Rezoning Transportation Analysis

Petition Number: 2021-096

From: Brandon Brezeale, PE

Revision Log:

SHEET TITLE: TECHNICAL DATA
 SHEET NUMBER: RZ-1

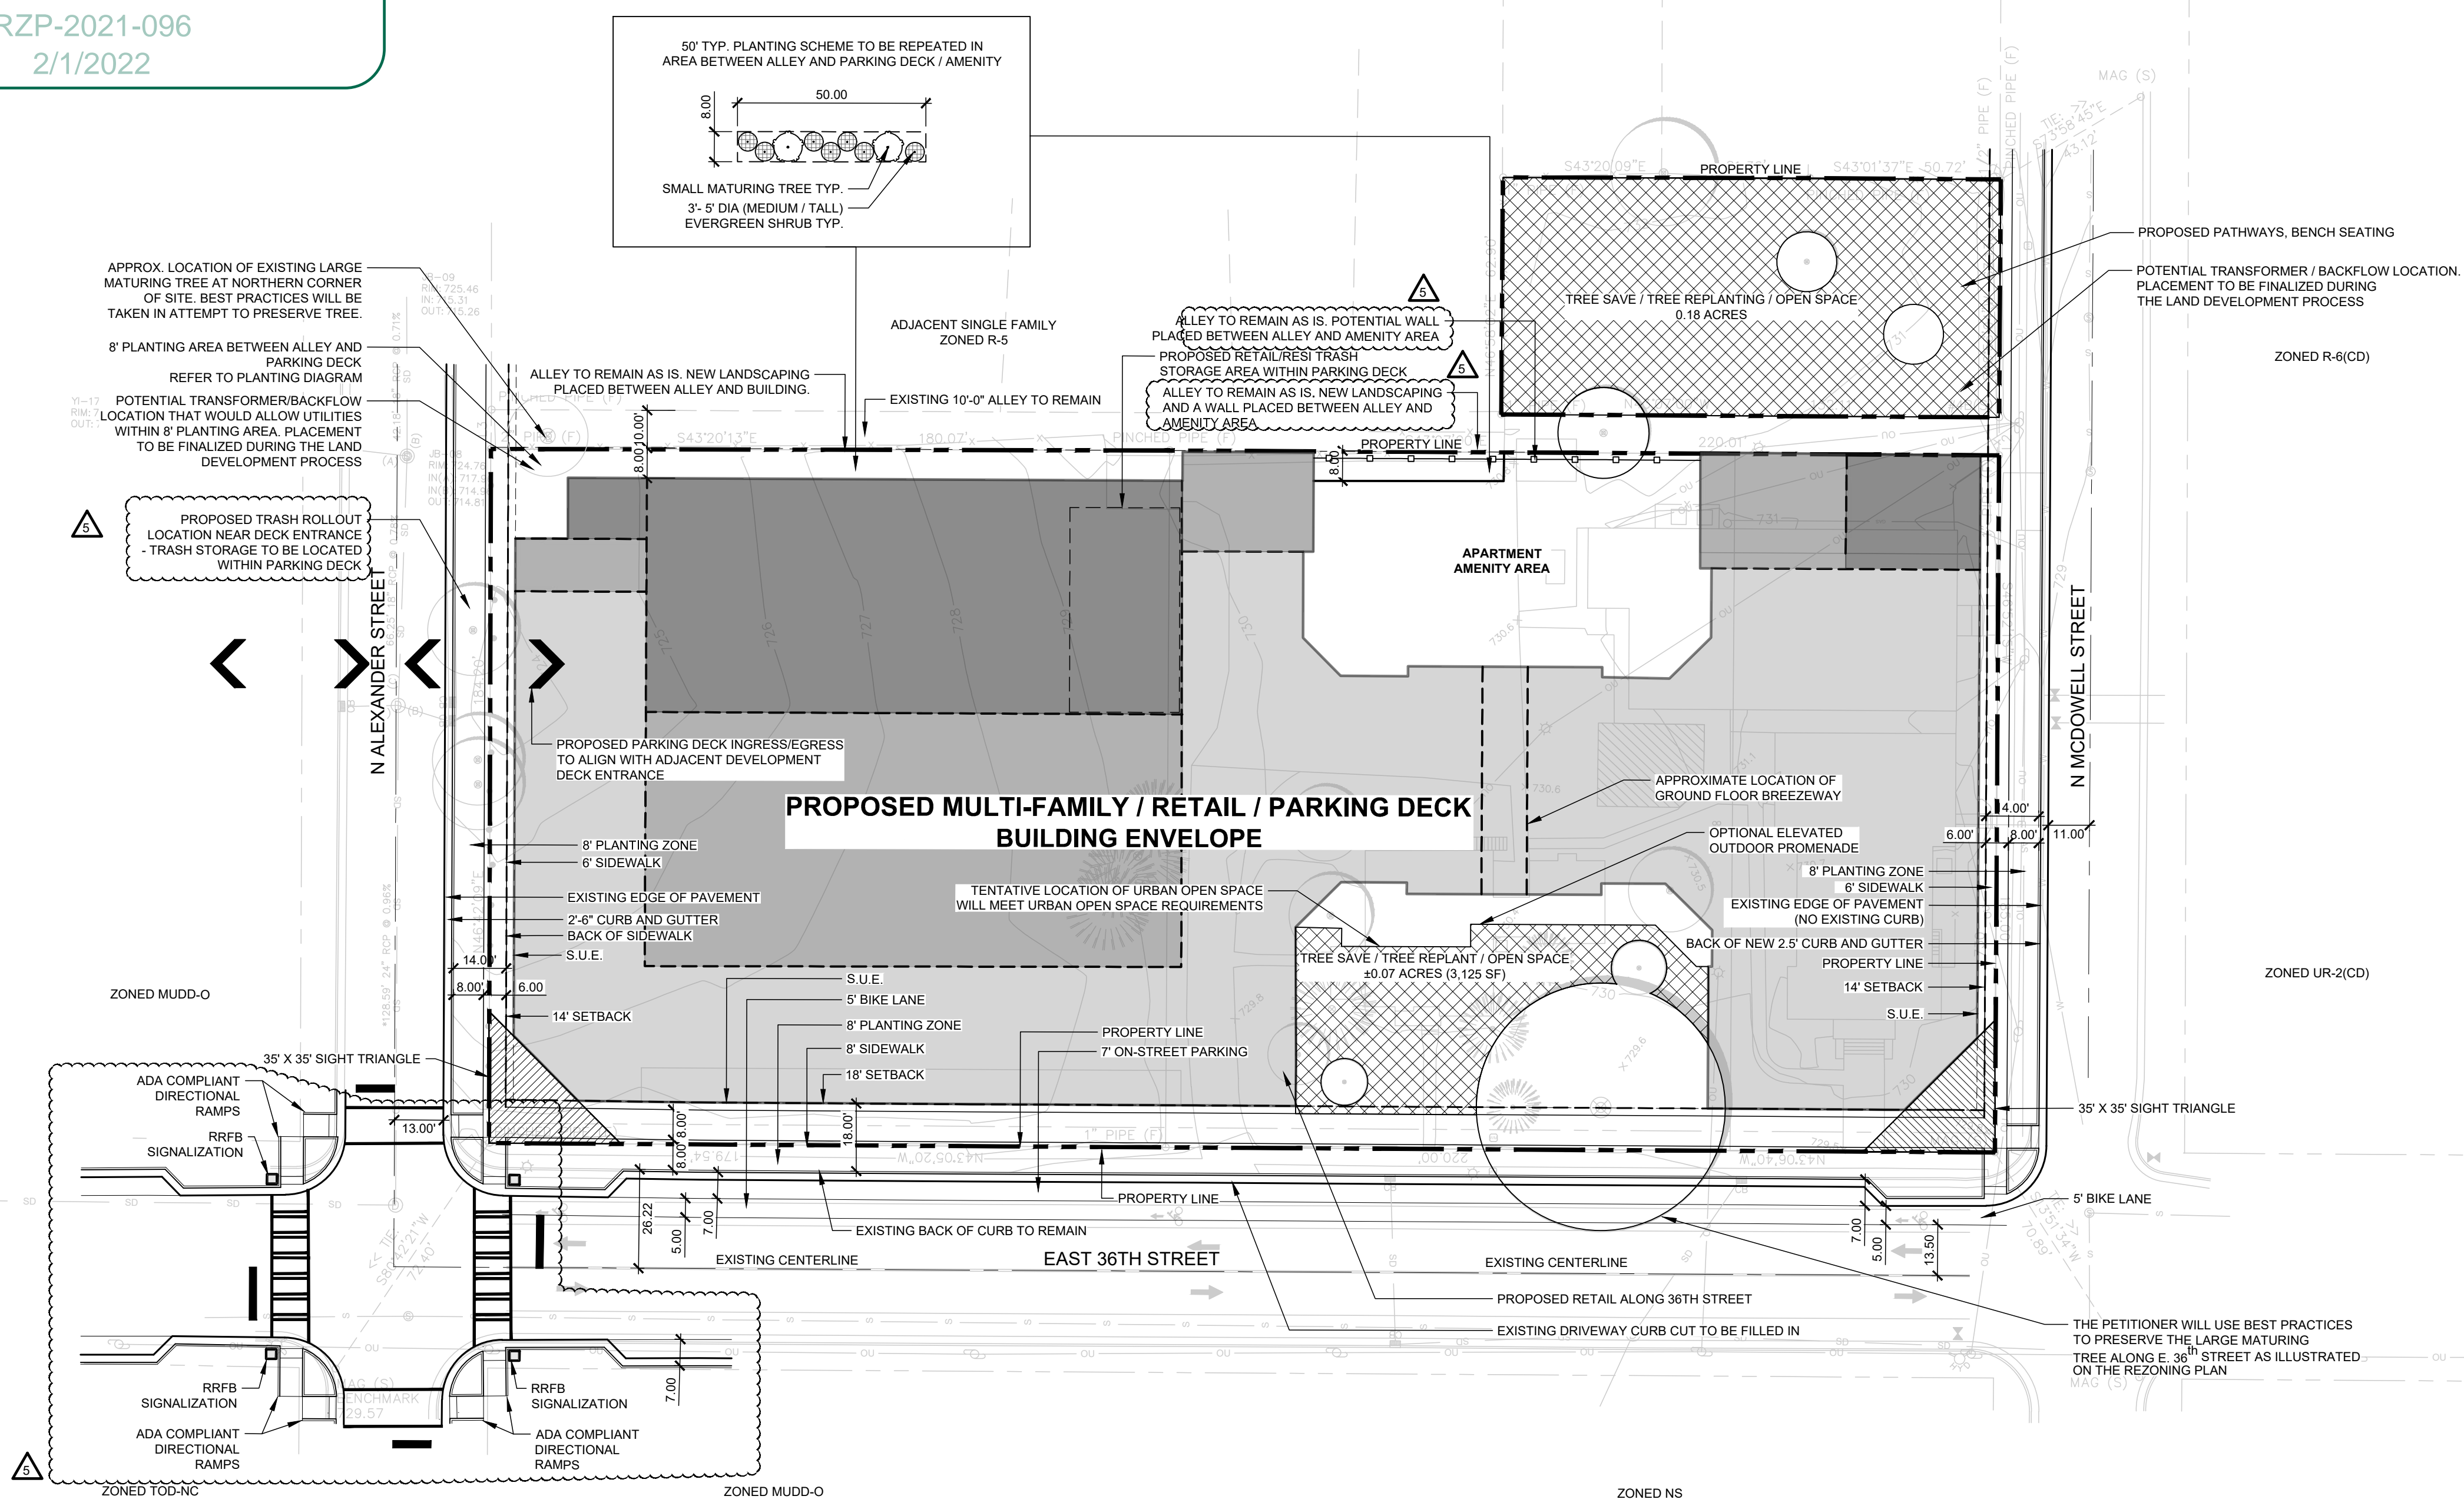
8. ~~Revise site plan to construct bulb-outs on East 36th Street at the corners of at North Alexander Street and North McDowell Street. Provide recessed on-street parking on North Alexander Street and North McDowell Street as SHOWN in the graphic below. New comment in response to request from Noda Neighborhood Board.~~

Outstanding Comment from 10-19-2021: ~~Revise site plan to construct curb bulb-outs on all corners of East 36th Street and North Alexander Street.~~

9. ~~NEW COMMENT (10.19.2021)~~

~~Revise conditional notes to commit to installing a pedestrian crossing with a Rapid Rectangular Flashing Beacon across East 36th Street at Spencer Street. Final location of crossing to be coordinate and approved by CDOT during permitting.~~

SHEET NUMBER  
**RZ-1**

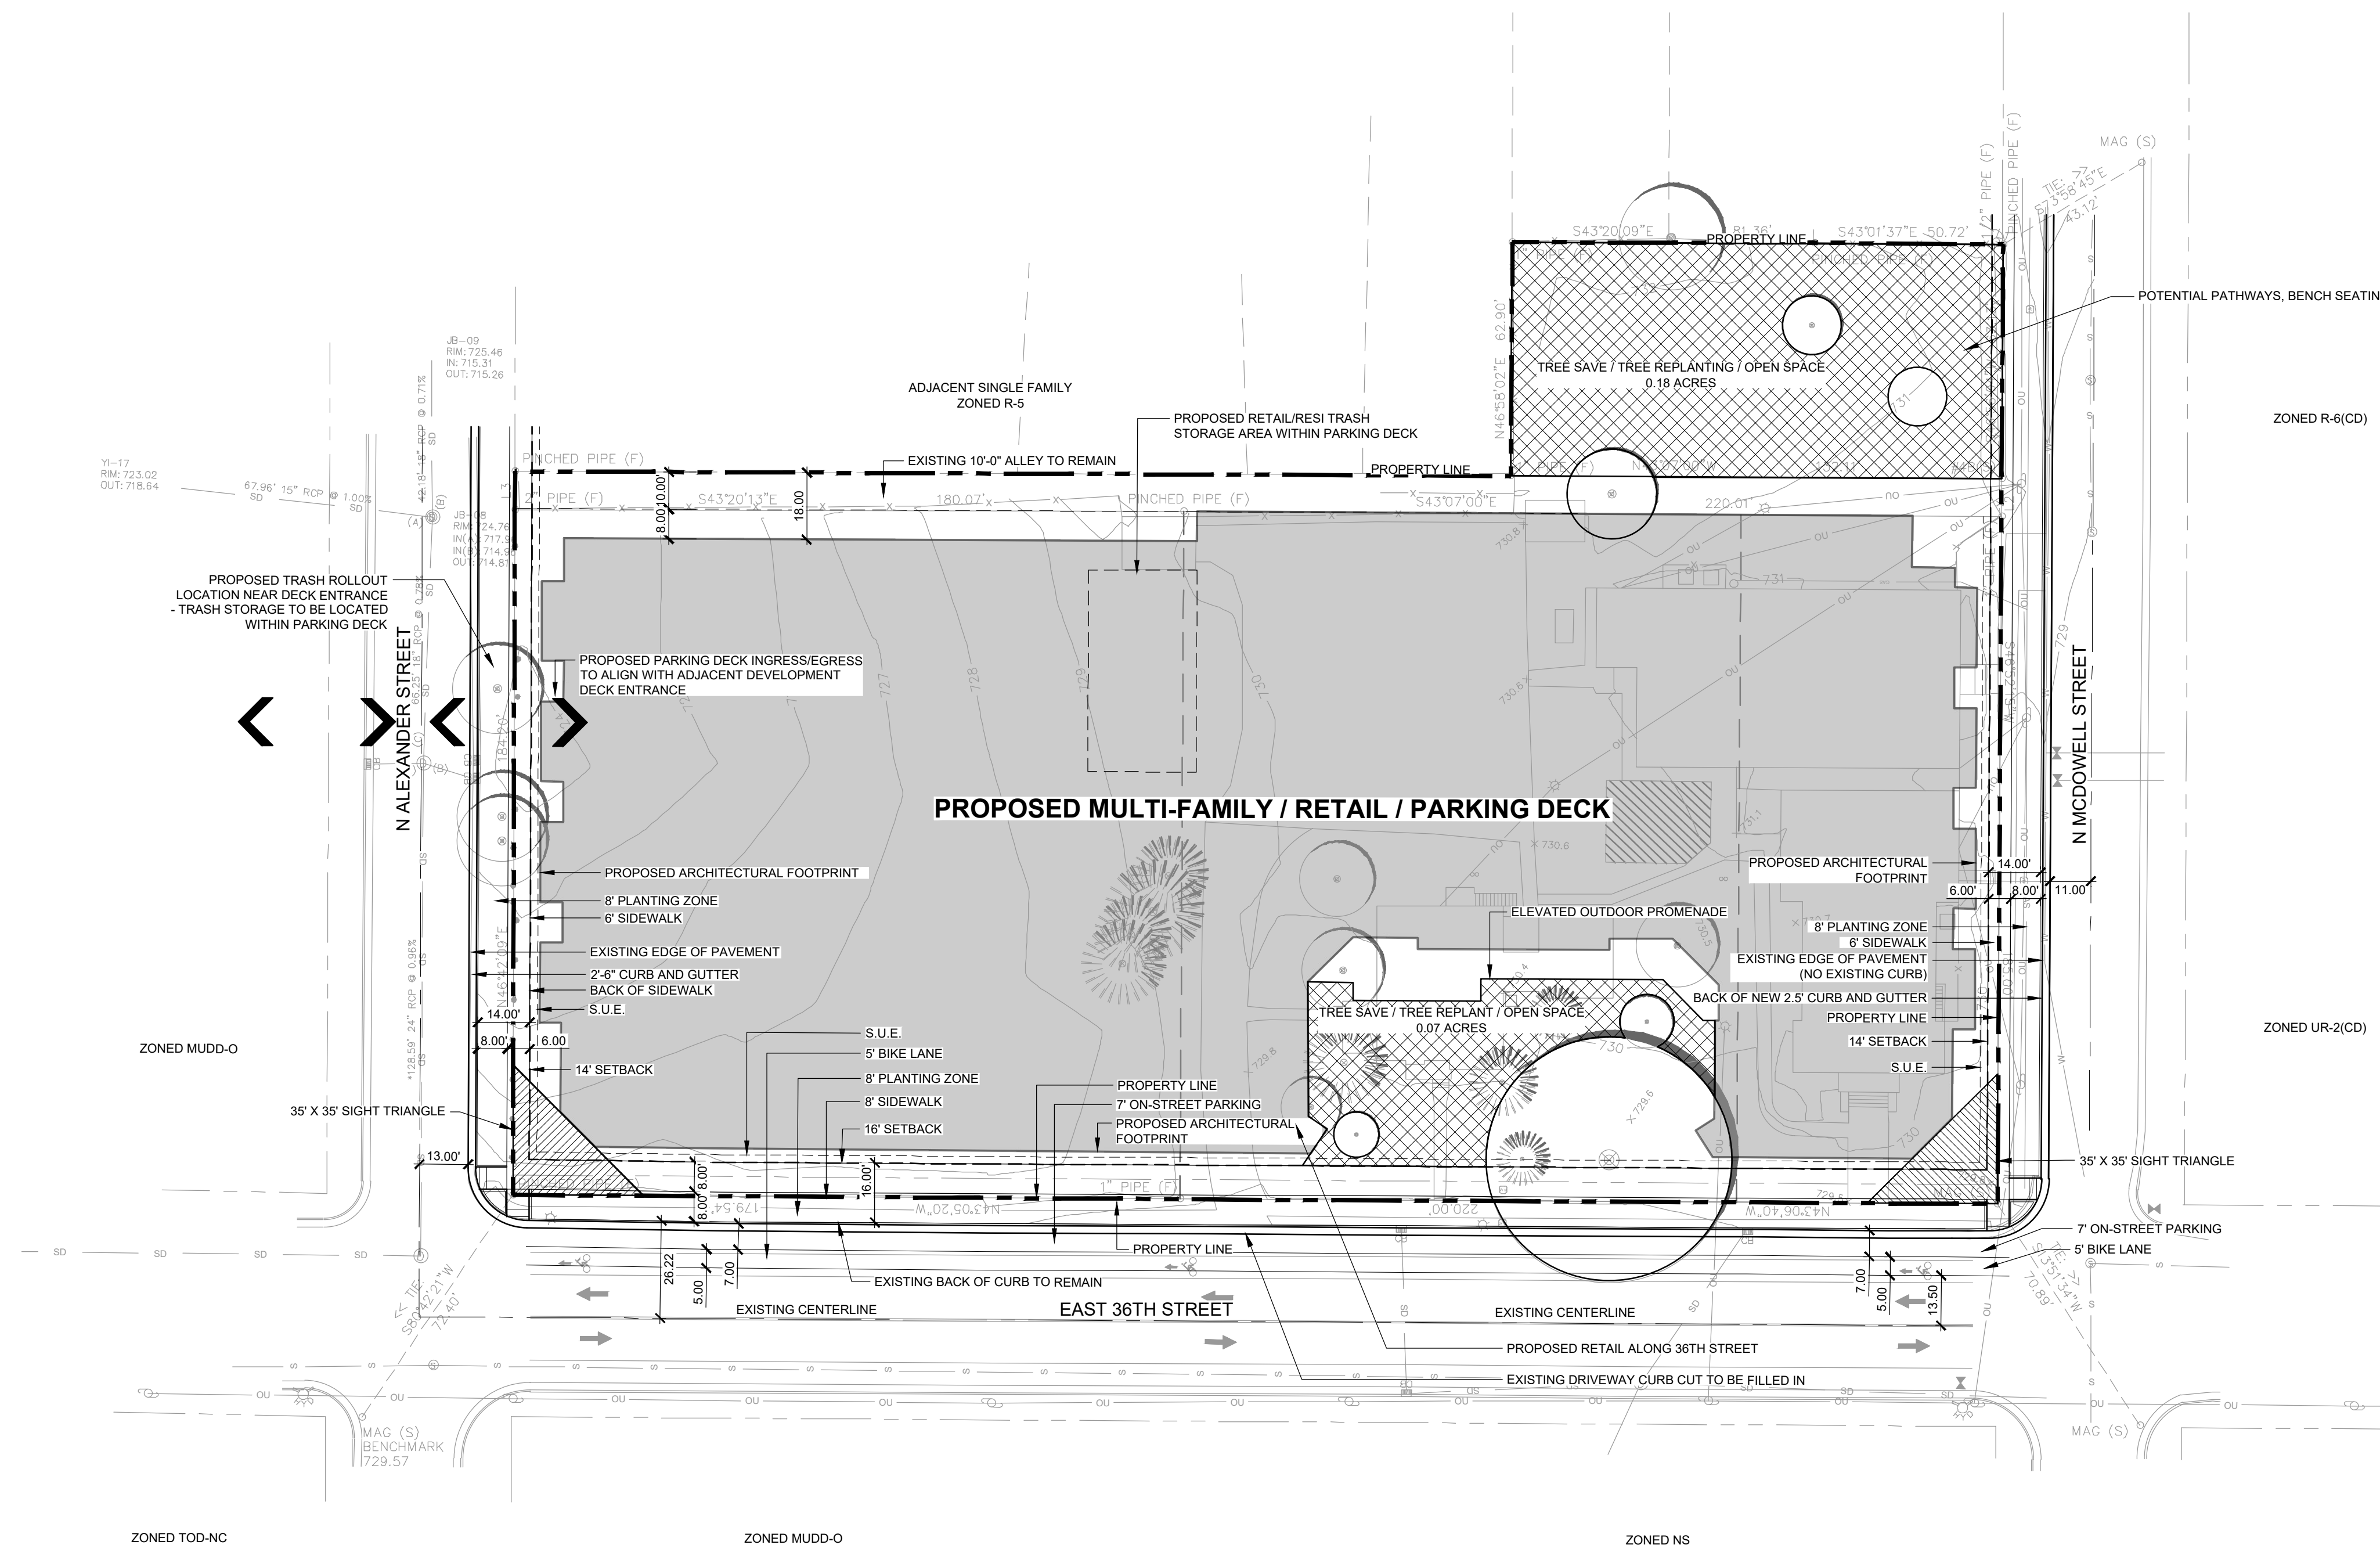
- ~~2. Revise site plan to reflect 10' x 10' sight triangles at the intersections of East 36th Street with North Alexander Street and North McDowell Street.~~

- ~~3. Revise site plan to indicate two curb ramps at the intersections of East 36th Street with North Alexander Street and North McDowell Street.~~
- ~~4. Revise site plan to indicate proposed access point(s).~~

- ~~5. Revise site plan to include dimensions of bike lane and on-street parking. Cross-section needs to be symmetrical from centerline street (bike lane and on-street parking on both sides)~~

- ~~6. The unused alley in the northwest corner of the site is for the benefit of all adjoining property owners and may not be planted unless it is formally abandoned.~~

- ~~7. Revise site plan to show replacing valley gutter on the North Alexander Street frontage with standard 2'6" curb and gutter to match the curb on the opposite side of North Alexander Street.~~
